Charlotte Department of Transportation

Memorandum

Subject: Rezoning Petition 08-035: Located on both sides of Statesville Avenue between Woodward Avenue and Dearborn Avenue (revised 1/18/08)

SP101

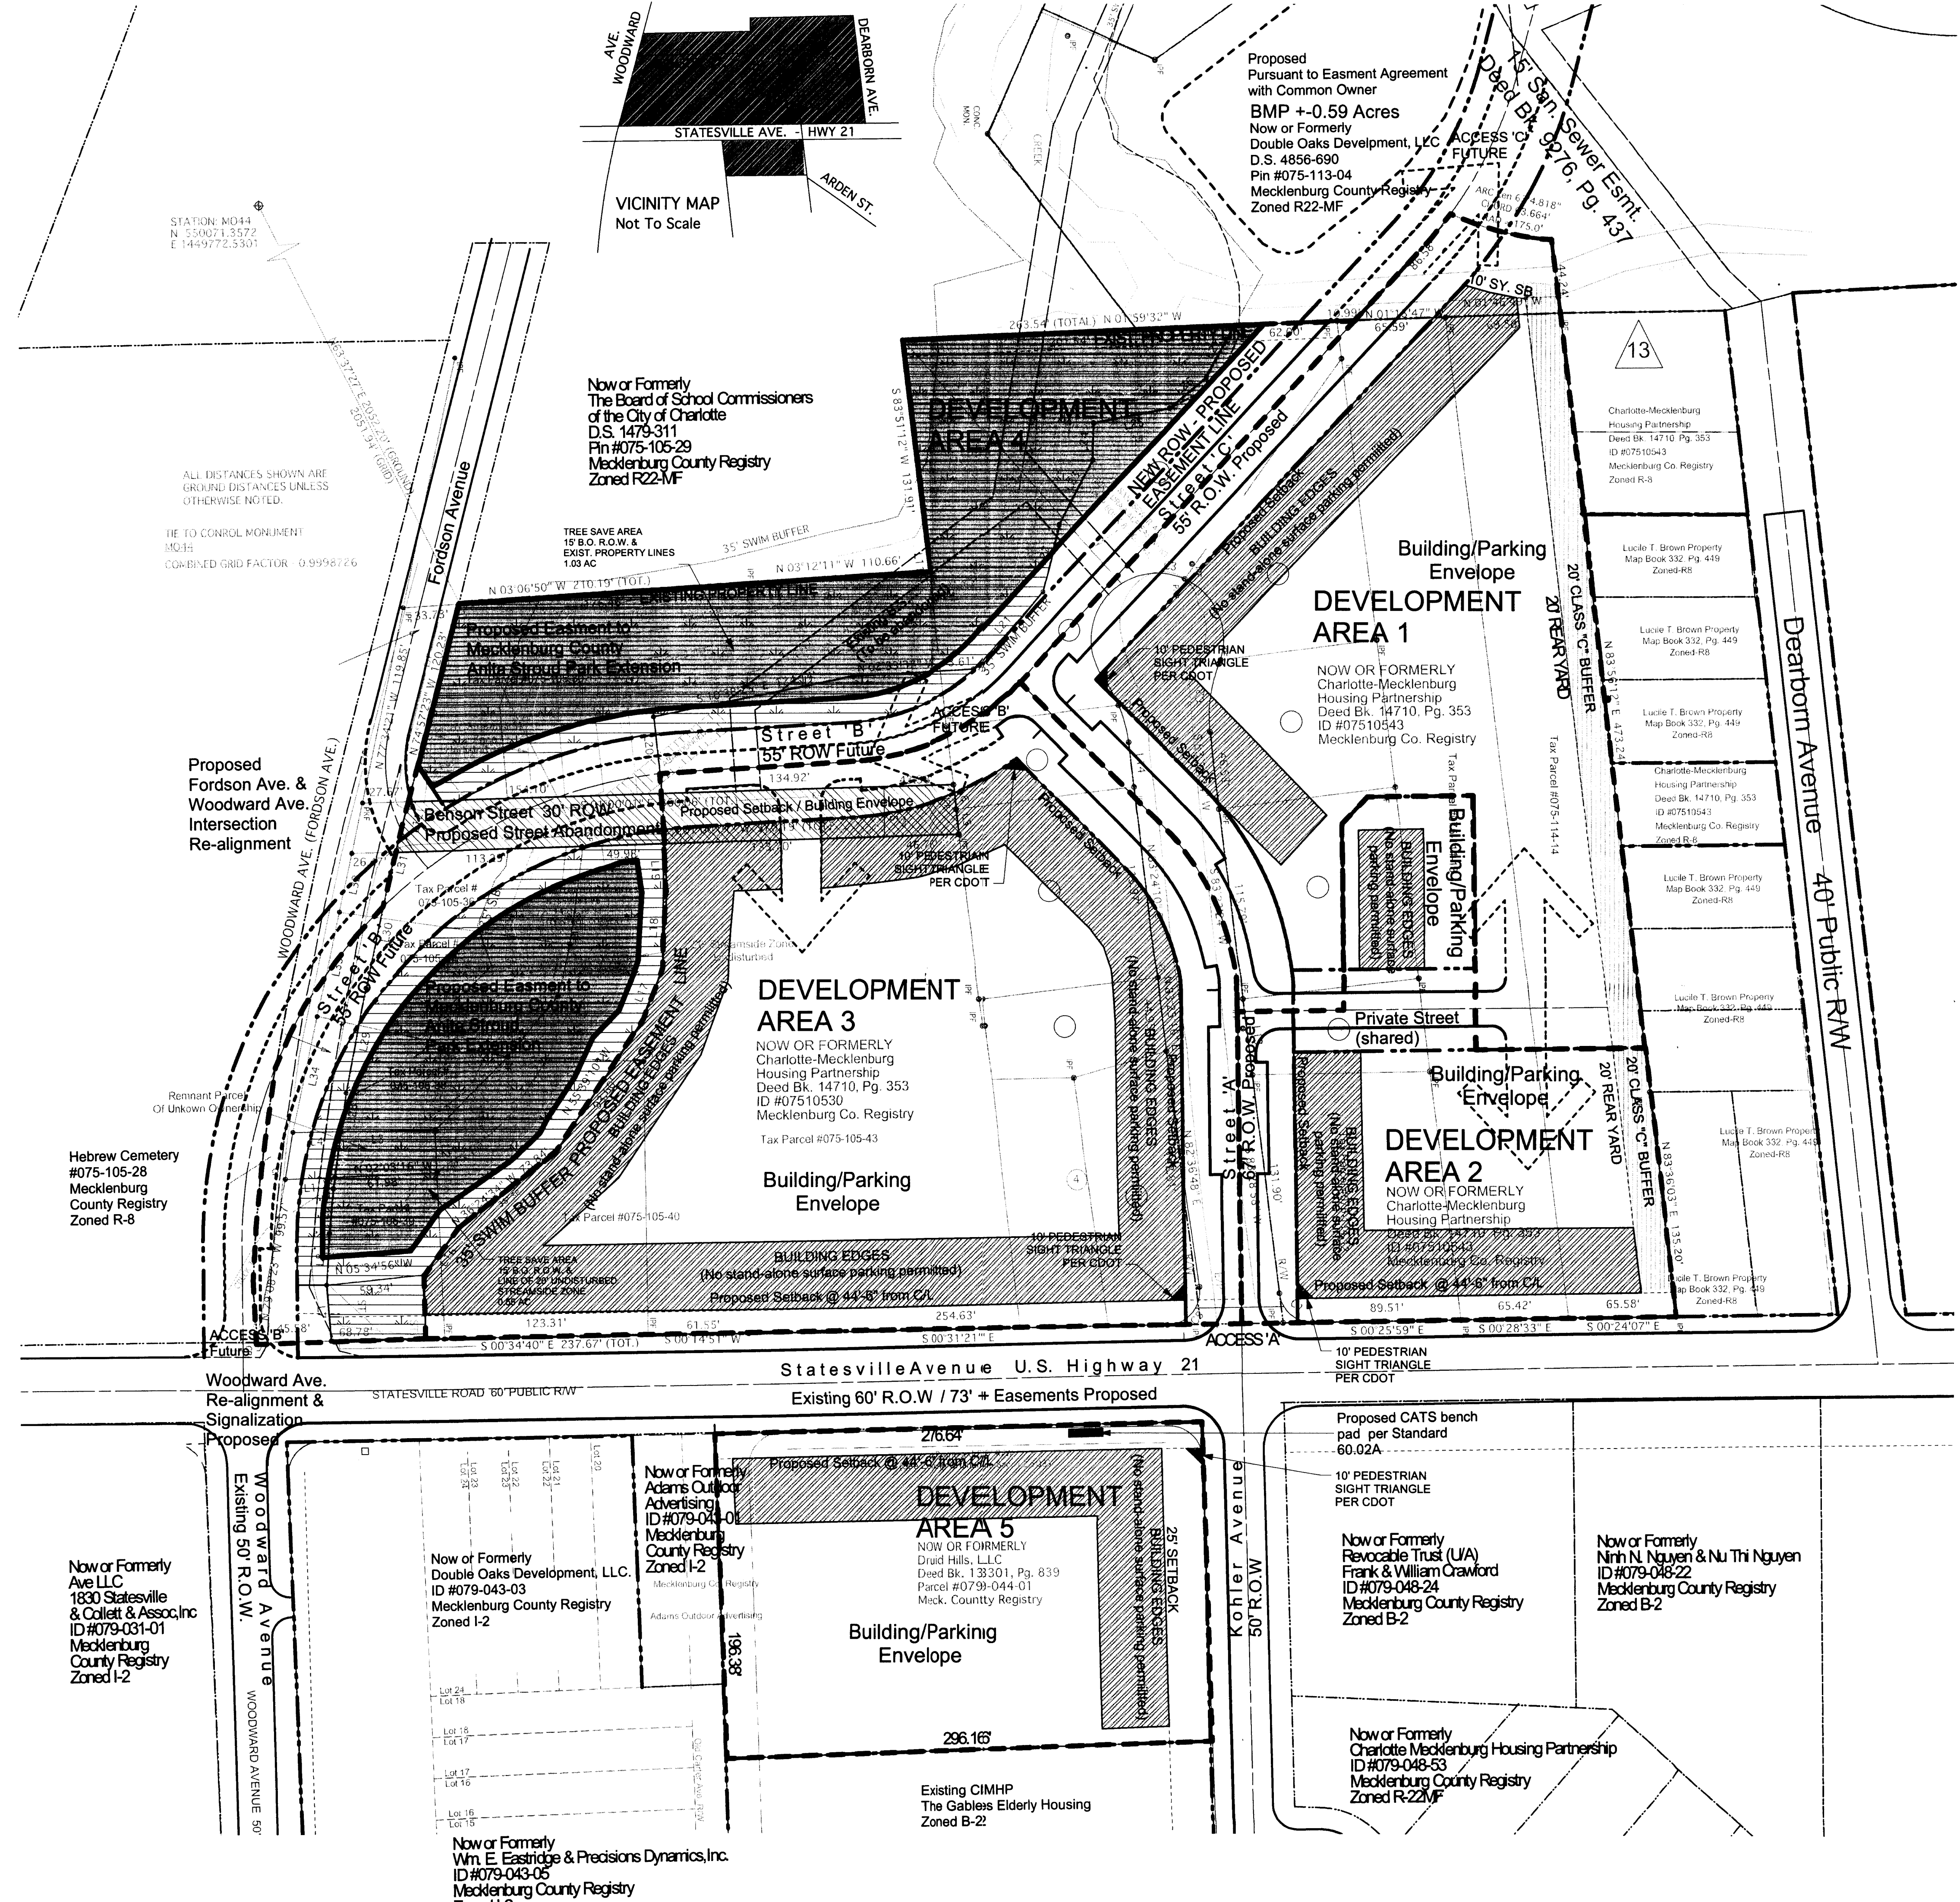
3. Should CDOT/NCDOT approve the proposed installation of a traffic signal at the Statesville Road/Woodward Avenue intersection as identified on the site plan, the petitioner/developer is responsible for all costs associated with its installation.

Statesville Ave. Proposed Section

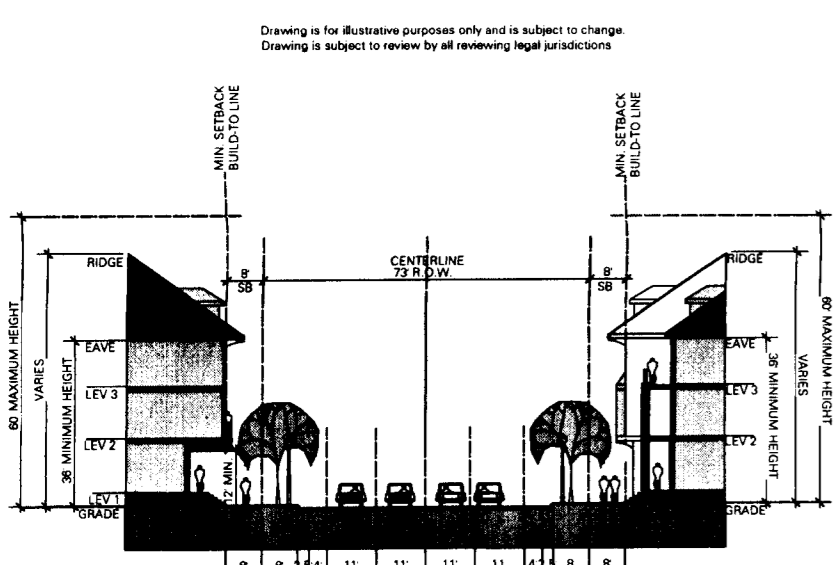
1. The proposed typical cross-section for Statesville Avenue needs to be revised to show four 12-foot lanes and a 4-foot concrete median. (28 feet from centerline to face-of-curb) This is the typical section required by NCDOT. After the submittal and review of the traffic study by both CDOT and NCDOT as described in note 2.10, left and/or right-turn lanes may be required on Statesville Avenue at the Woodward and Kohler Avenues street connections.
